BCA ASSESSMENT REPORT

Building 2B, Oakdale West Estate

SSD 7348 Mod3 & SSD 10397 Stage 2 DA

Revision 3

Figure 9: Perimeter Access and points of non-conformity (Point '1' discontinuous travel path, Point '2' restricted width at gates and security control points, Point '3' pathway >18 m from the building)

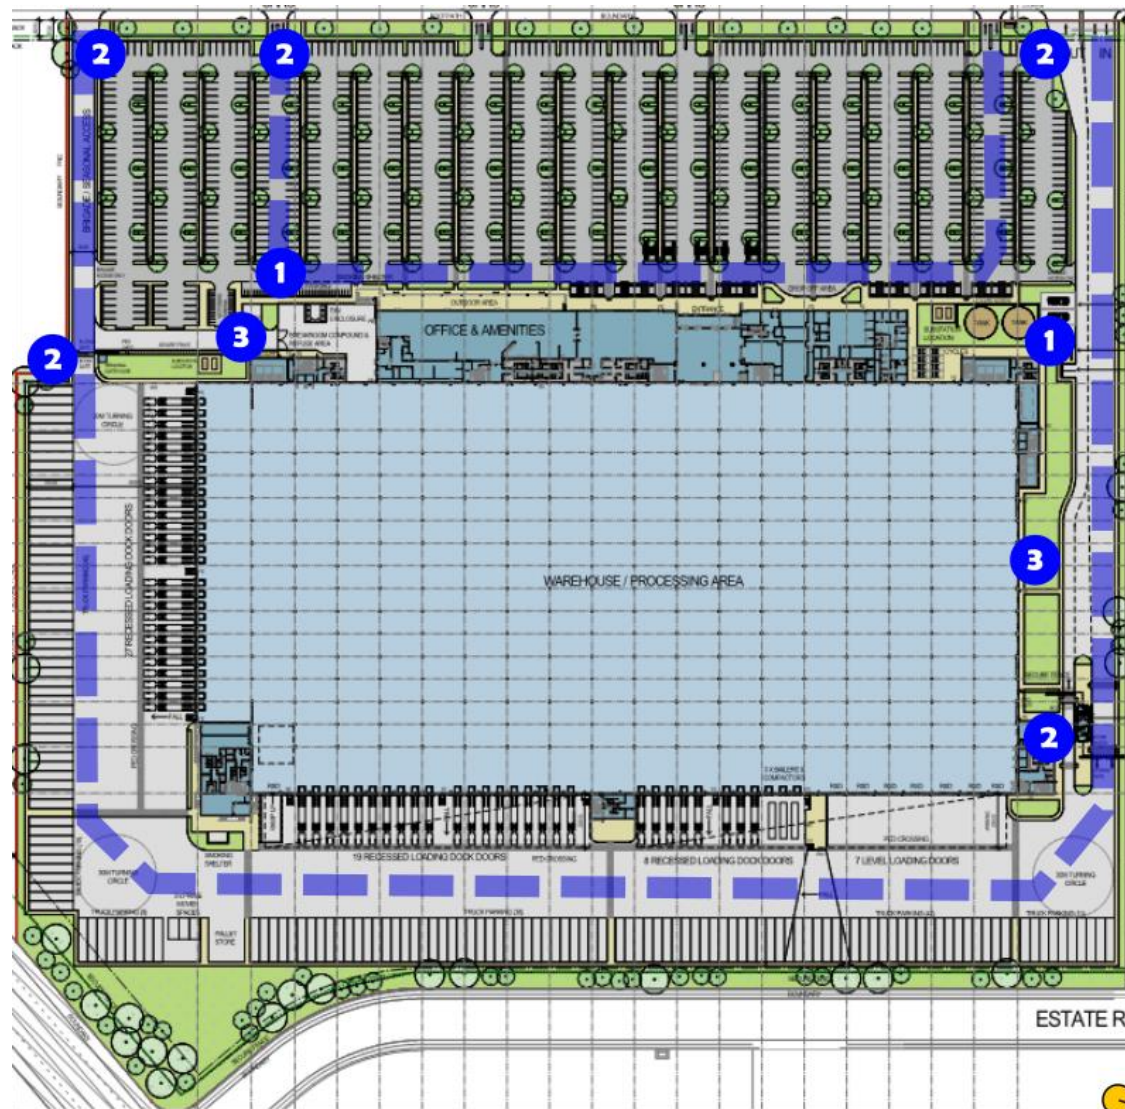
Comments: The proposed warehouse building complies with the provisions of C2.4 with the exception of the areas circled in blue on the mark-up below that are required to be addressed as a performance solution by the Fire Safety Engineer:

- + Vehicular Access is greater than 18m from the external wall of the Building along the northern elevation and in the NW & SW corners of the site.
- + Vehicular Access is discontinuous in the NW & SW corners of the building.
- + Vehicular Access via the Staff Carpark on the Western side of the building is not likely to comply with the FRNSW Policy 4 vehicular access guidelines and the width of the entries to the carpark will be less than 6m.
